CITY OF PORTLAND BUILDING PERMIT

Job ID: 2011-07-1652-ALTR

Permit - 2011-07-1652
amendment - 2011-12859

RE: 93 Westland Avenue Renovation project

SK-1  
1 OF 5

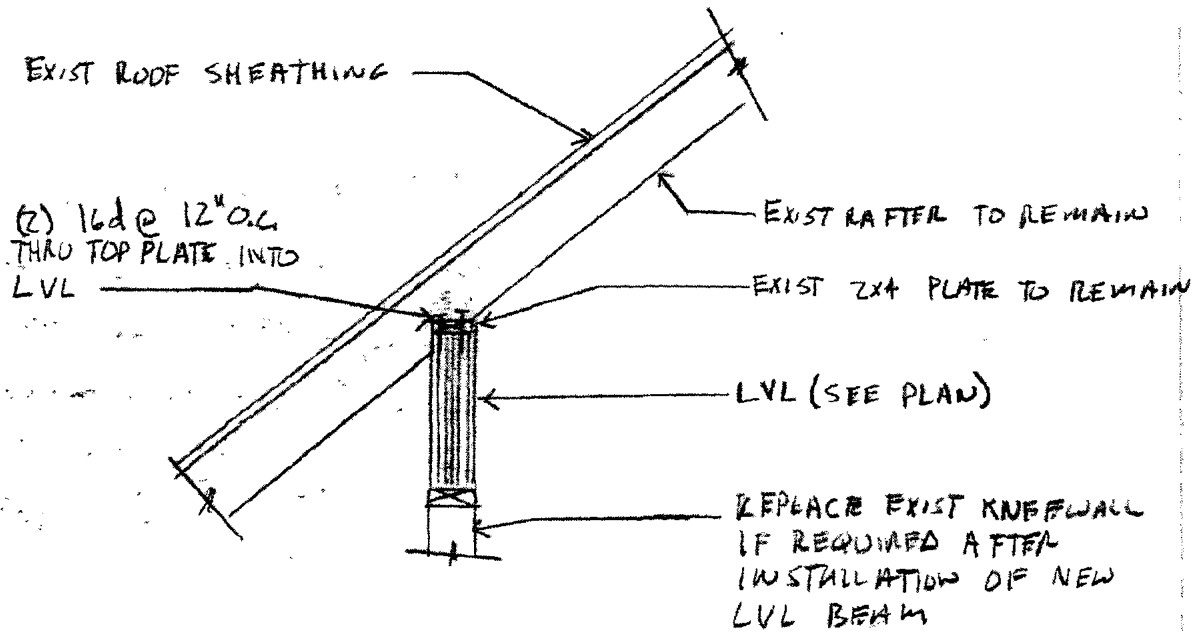
The first item I reviewed was a ridge beam running from the southwest side of the house (labeled Ridge Beam 3 on Sketch SK-1). The ridge beam is a 1 3/4" x 11 7/8" LVL, and spans approximately 23'-0". This existing ridge beam was found to be overstressed according to current building code requirements. It is recommended that the contractor install a vertical support to reduce the span of the ridge beam to meet current building code requirements. The installation of this support is detailed on the attached sketches.

SECTION Z  
3/4" = 1'-0"

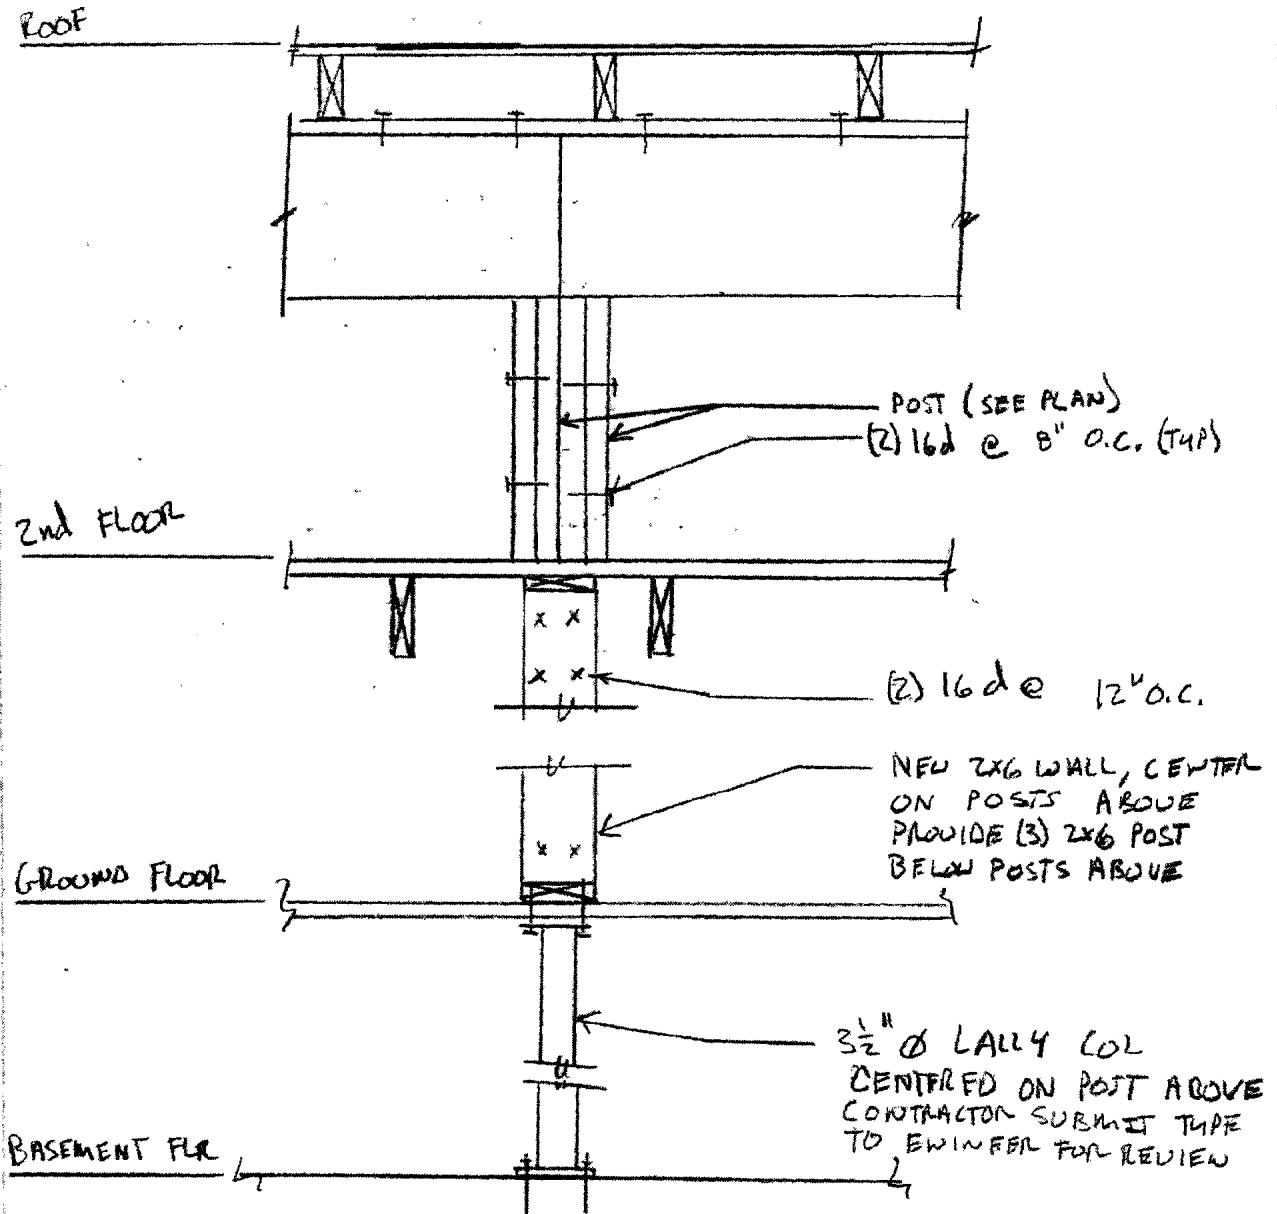
The second issue I reviewed was the roof rafters on the North side of the building. The original roof was reportedly lifted at the ridgeline to allow for more living space on the second floor. The rafters currently bear on the exterior wall at one end, a new knee wall at center span, and a new ridge beam at the other end. The new knee wall at center span is supported by the second floor framing. New rafters were sistered alongside the existing rafters to span from the knee wall to the center ridgeline. Upon review of this framing for code compliance, I found that the floor below the knee wall lacked the structural capacity to carry the roof loads from above. I recommend removing the existing knee wall and installing two LVL beams to remove the roof load from the existing floor framing. Details of this recommended repair are shown on the attached sketches.

SK-3
3 OF 5

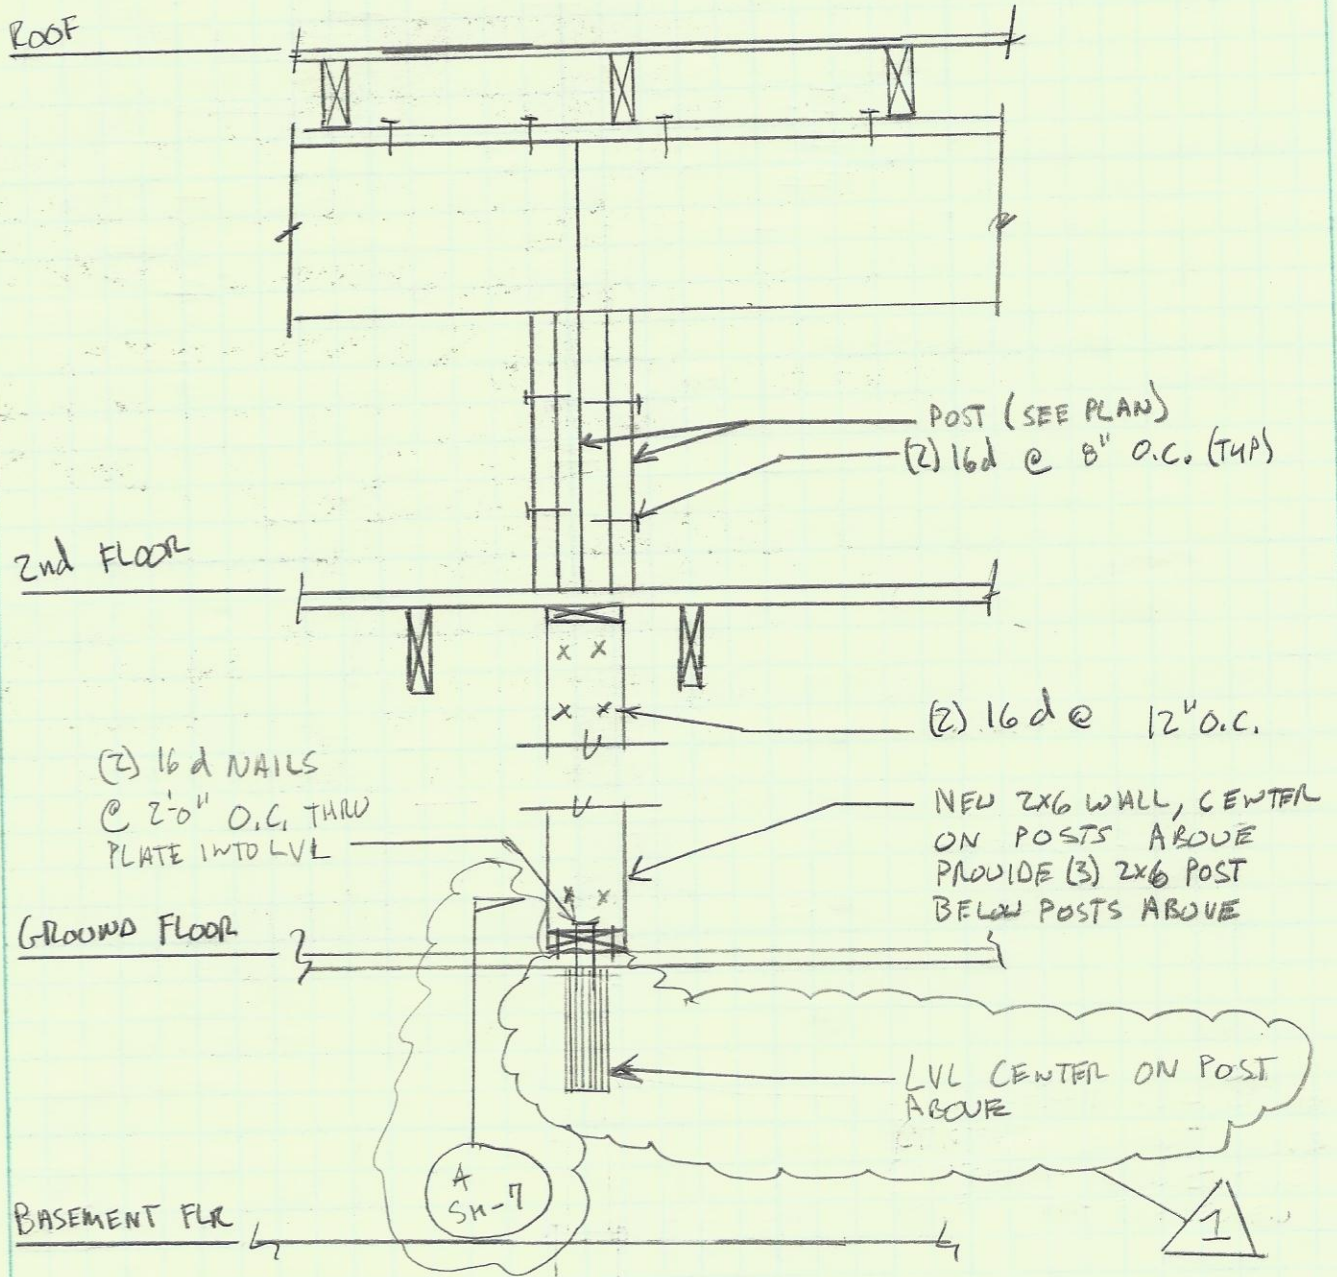
Please find an engineer's drawing describing the posting of the LVL in the upstairs that was added to support the building's original roof at the kneewall. This modified drawing now includes an additional LVL and Simpson hanger in the basement that we decided to add so that the lolly column posting could be moved to the center-line of the building.
